Re: Response to Secretary's Environmental Assessment Requirements (SEARs) for the proposed modification to the Concept Plan Approval and Project approval MP 07_0026 - MOD 7 relating to Super Lot 5 (Lot 5 DP 1239938)

Re: Response to Secretary's Environmental Assessment Requirements (SEARs) for the proposed modification to the Concept Plan Approval and Project approval MP07_0026 MOD 7 Super Lot 5. Lot 54 DP 1222919.

**Mixed Use Development, Lennox Head Modification 7 (MP 07_0026 MOD 7)
Comment on the Secretary's Environmental Assessment Requirements (SEARs)**

**Pre-DA Advice - Proposed Modification 6 (Super Lot 7) and Modification 7 (Super Lot 5)
EPIQ Lennox (formerly known as 'Pacific Pines')**

EPIQ ESTATE - LENNOX HEAD, NSW, 2478 SUPER LOT 5 CIVIL WORKS PLAN			
Reference No. 140351	DRAWING No. 14351-S5-DA-CI-01	REVISION E

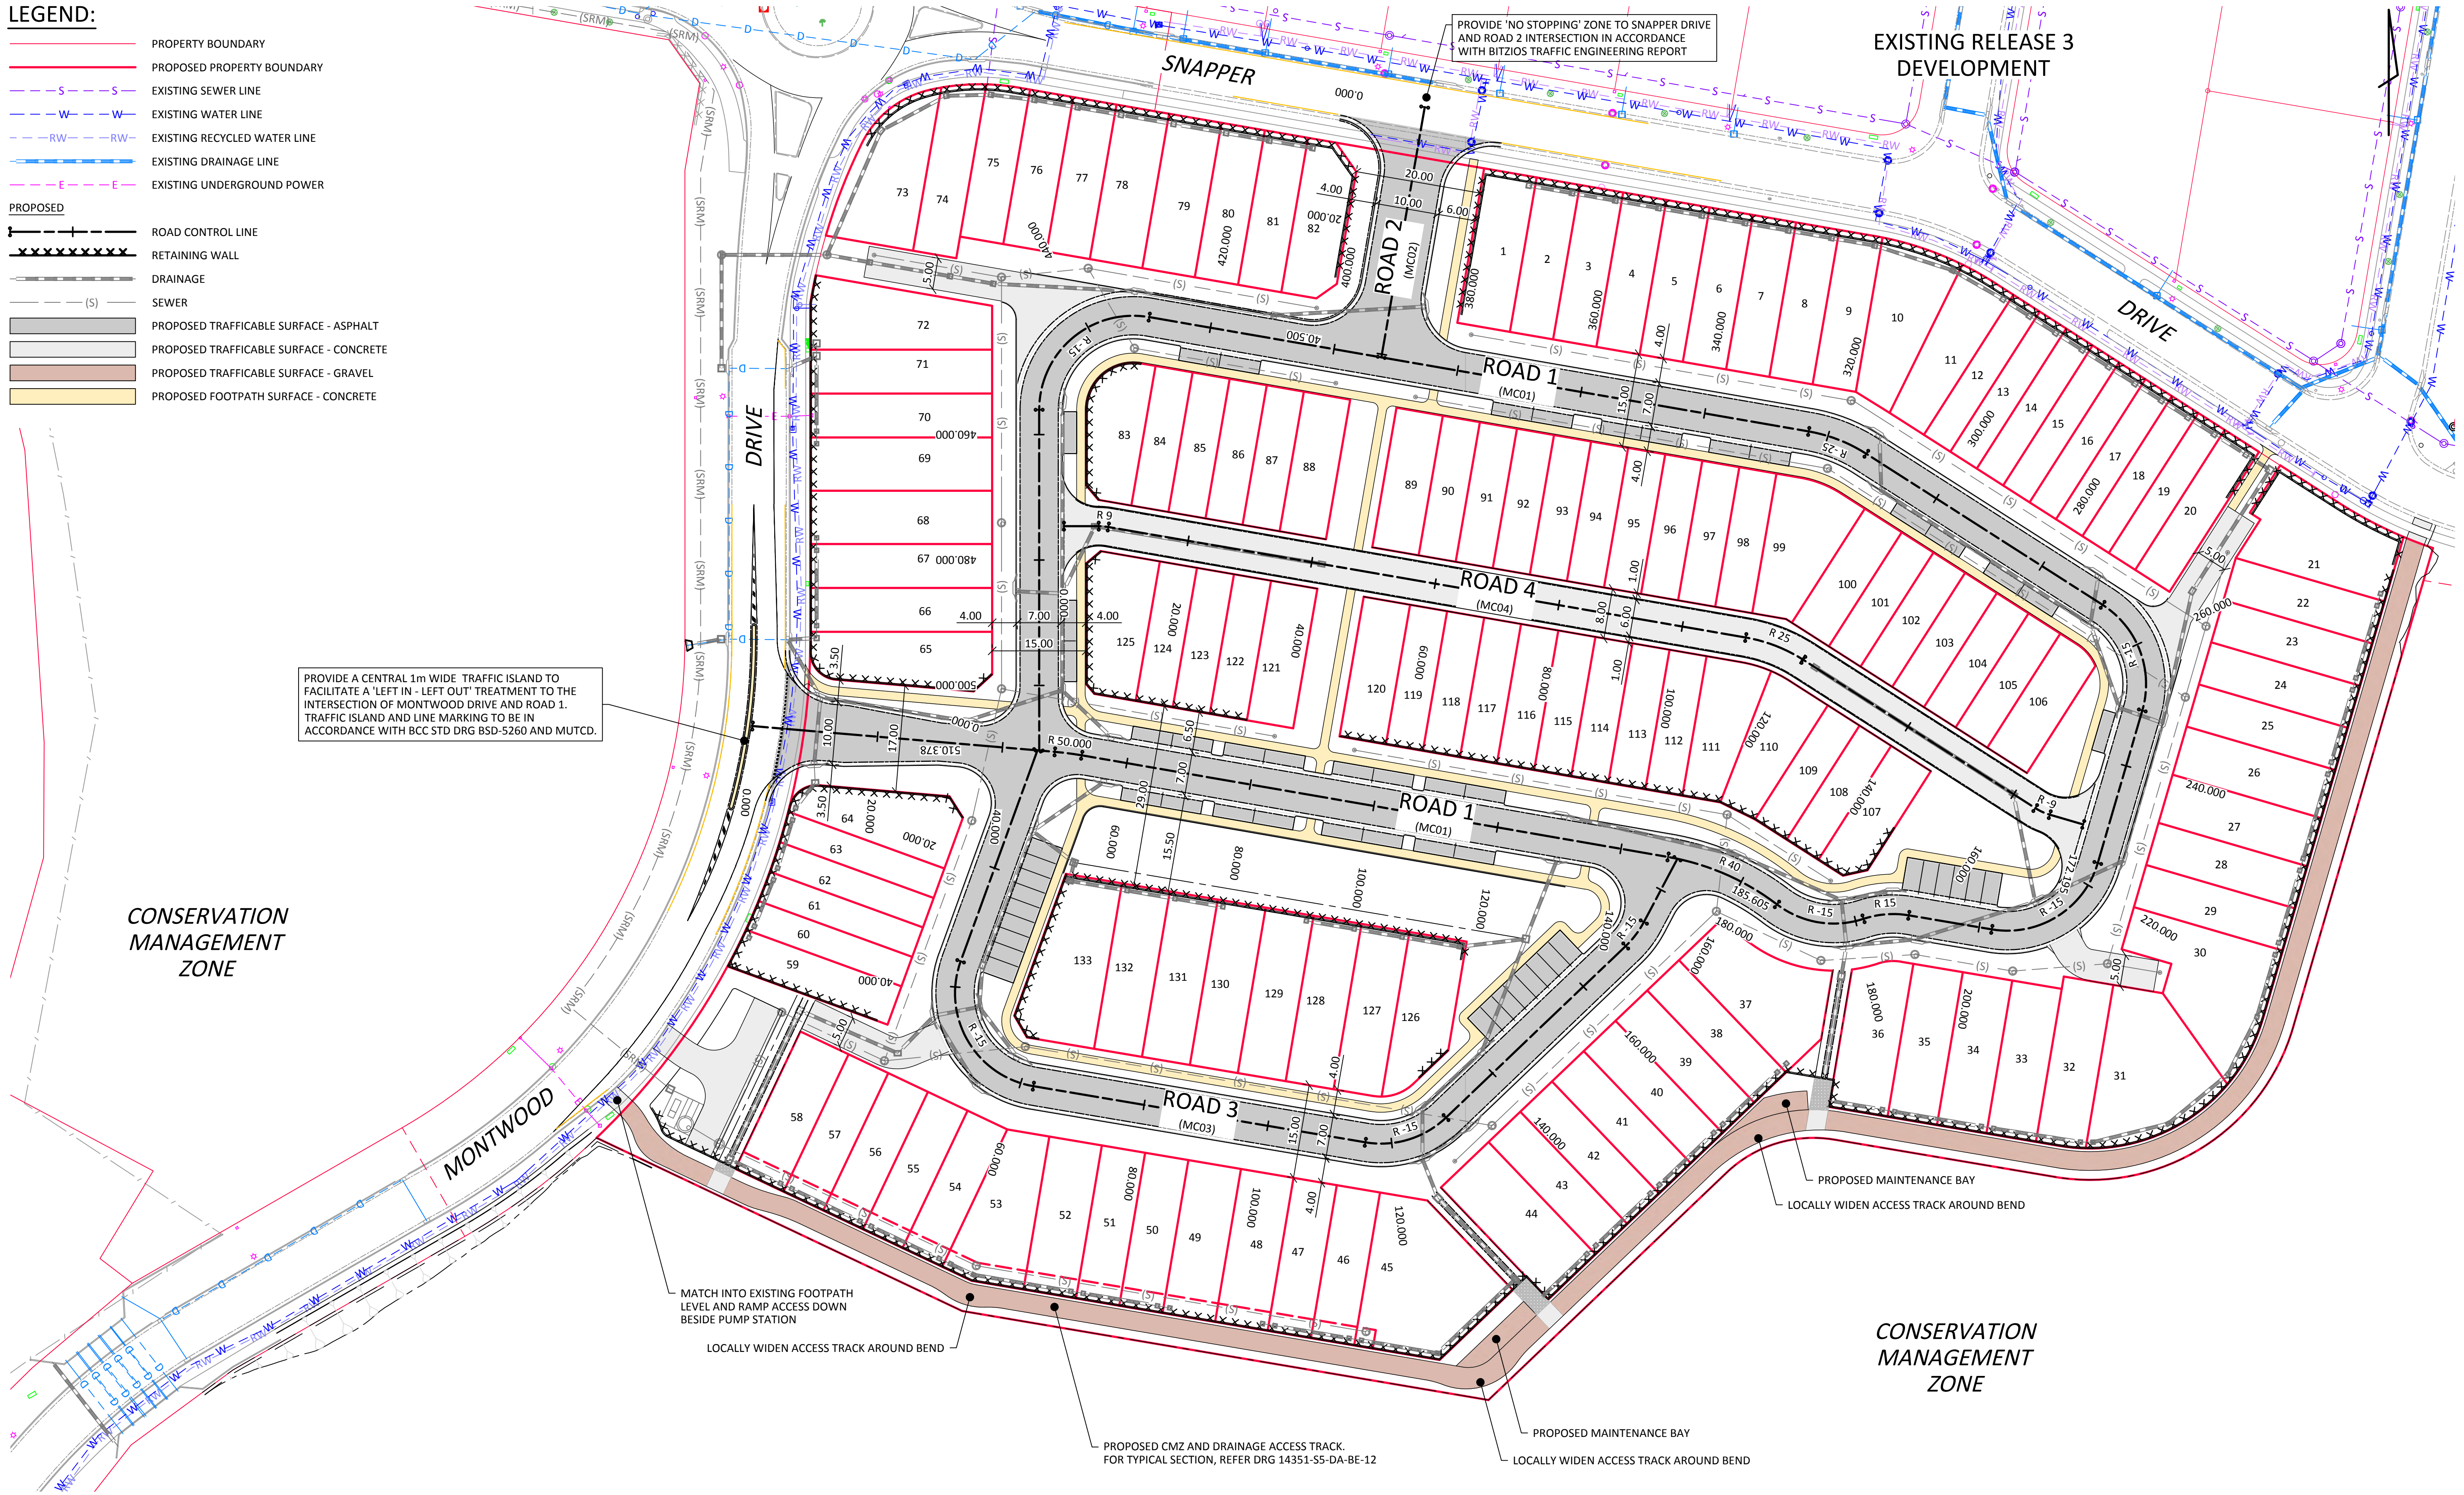
- A perimeter road shall be provided along the eastern and southern boundary of Super Lot 5, as proposed as part of the original Concept Plan Approval. This will provide a bushfire buffer to the conservation area (to be revegetated) and also minimise Council's ongoing vegetation maintenance requirements such as within other open spaces where Council spends significant resources maintaining vegetation, which directly adjoins private property. Further to this, the required maintenance would also be contrary to the intent of the conservation zones.

- The applicant shall give regard to the principles of Crime Prevention through Environmental Design (CPTED), with particular attention to the central laneway (proposed Road C) of Super Lot 5.

- The applicant should also provide an analysis of the proposed street system addressing compliance with the requirements of the Northern Rivers Local Government Design Manual, including but not limited to address of carriageway width and road reserve width.

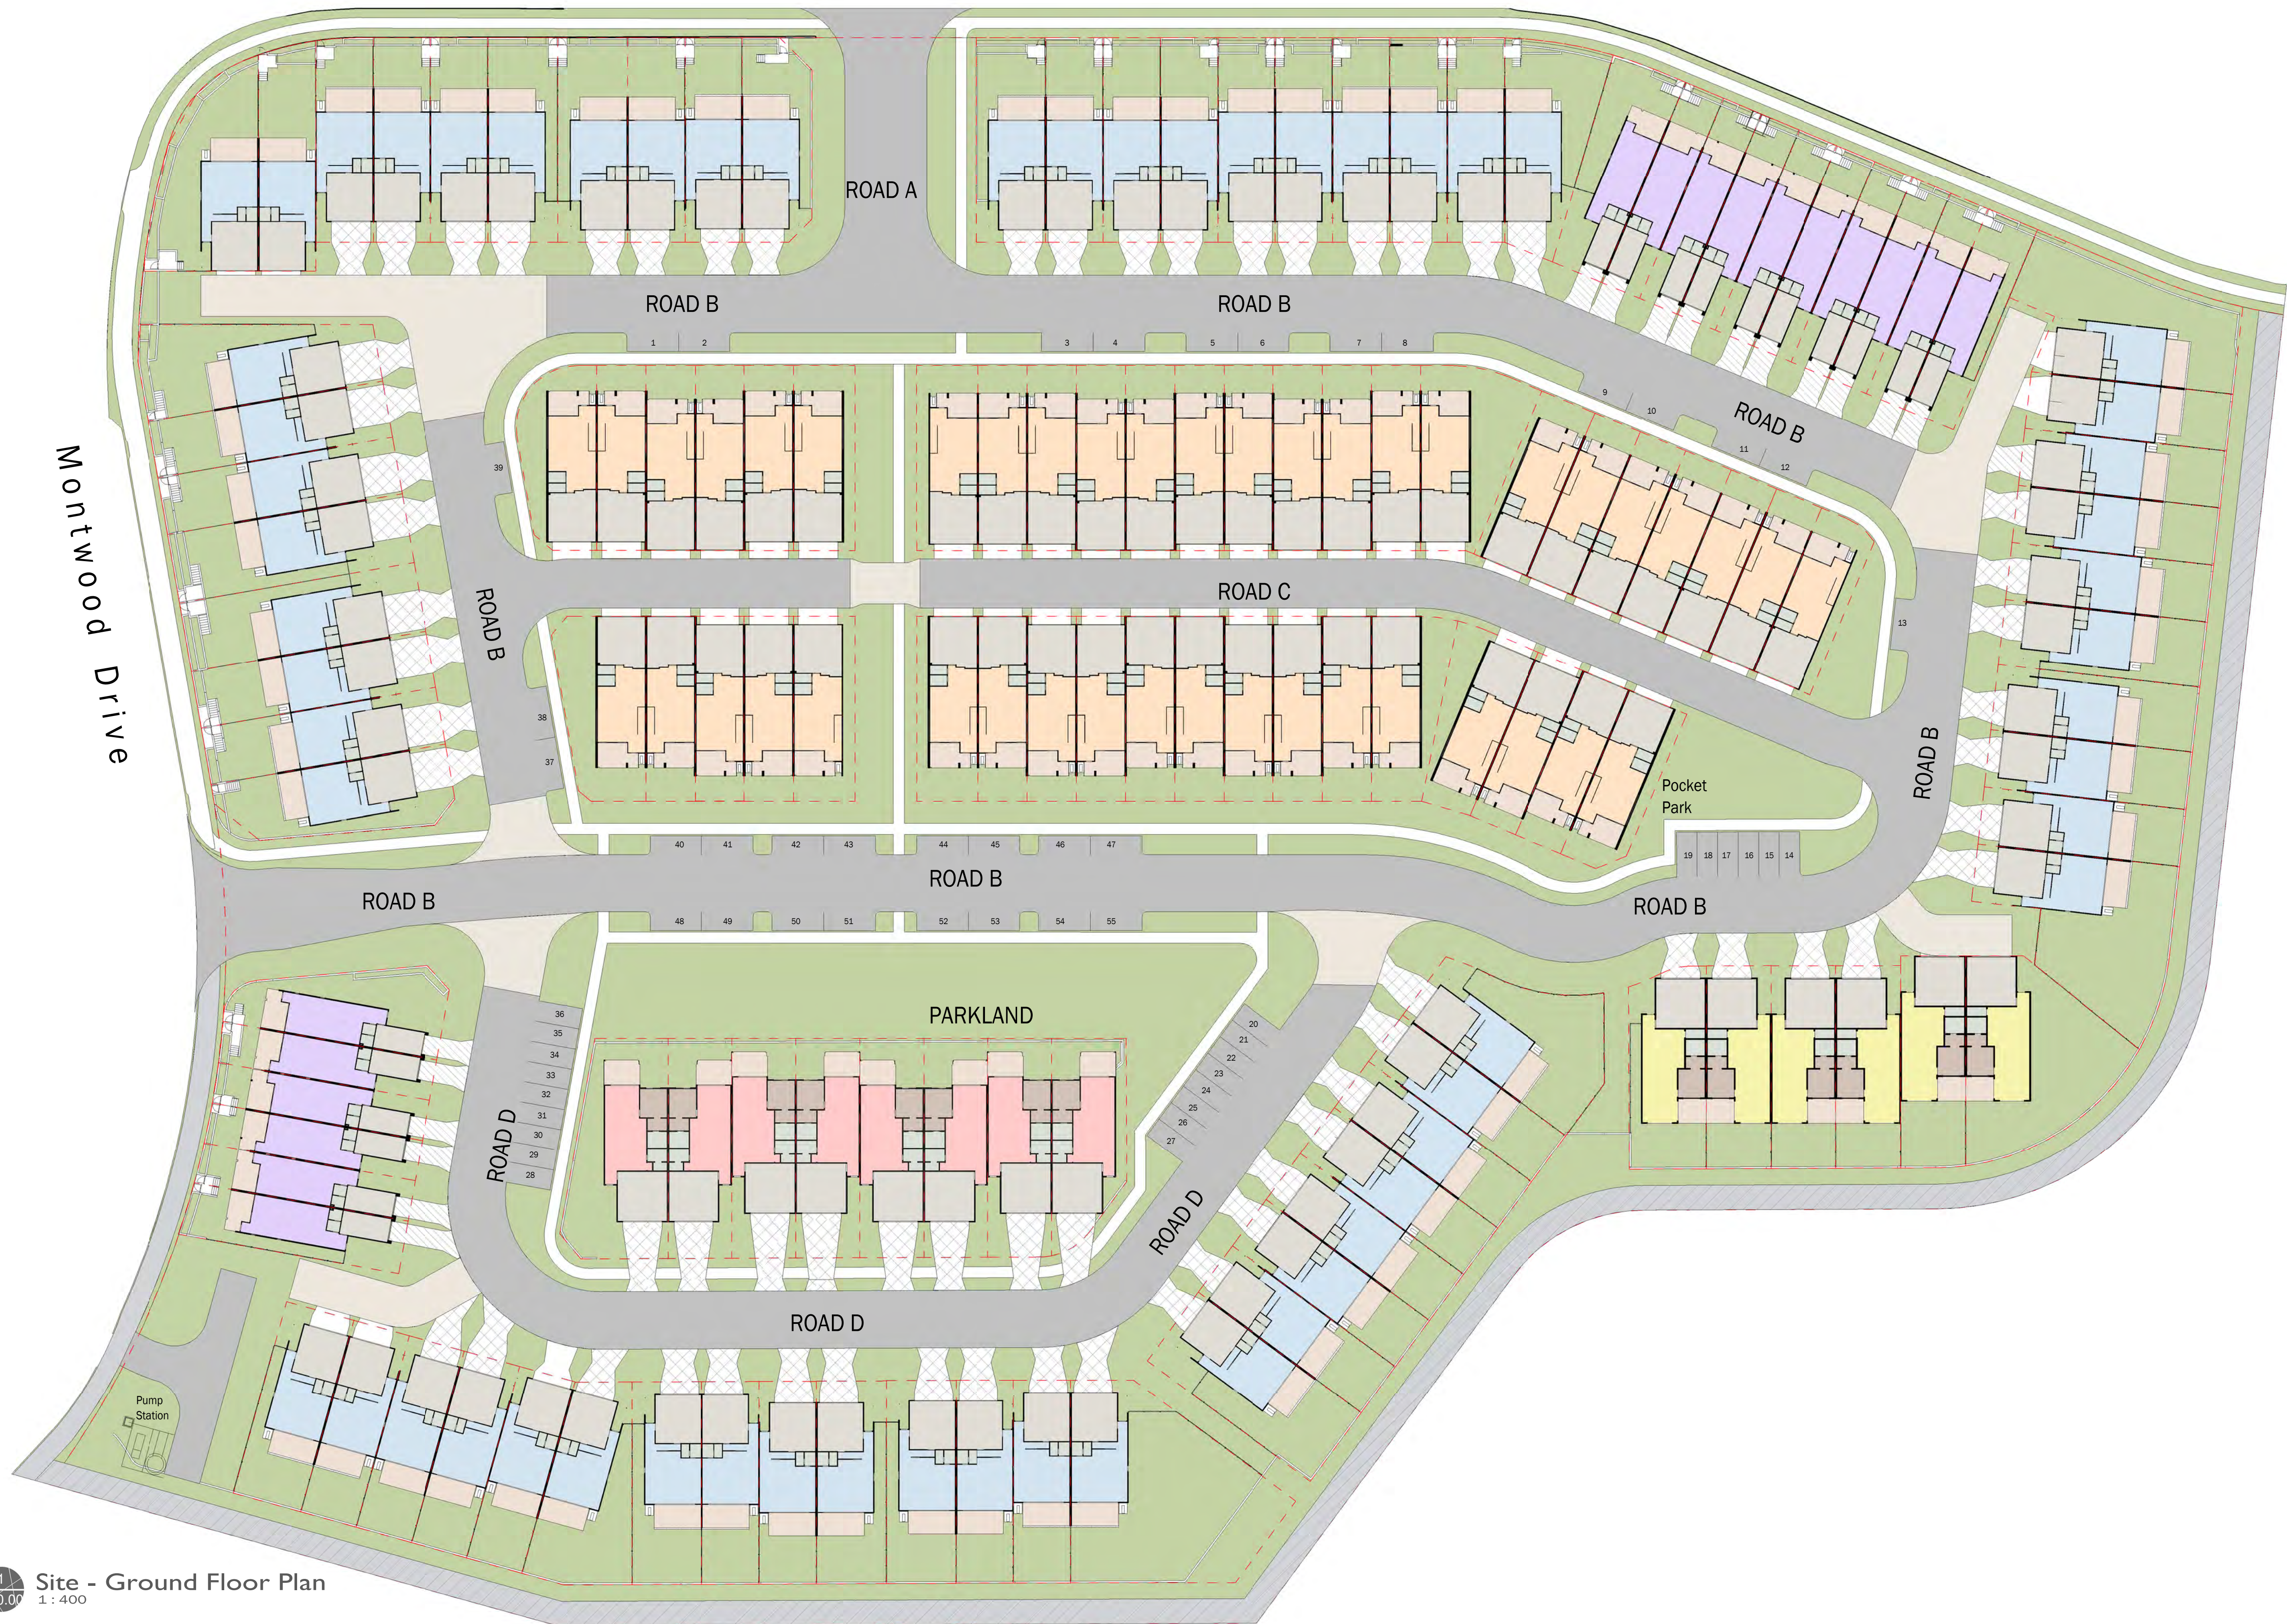
- It is recommended that single story buildings or further separation of the buildings are to be introduced to provide relief to the building form to break up the apparent bulk of the proposed building layout

- Given the density proposed for Super Lot 5, it is recommended that provision be made for a central neighbourhood park or public open space area, accessible to the residents of the area.
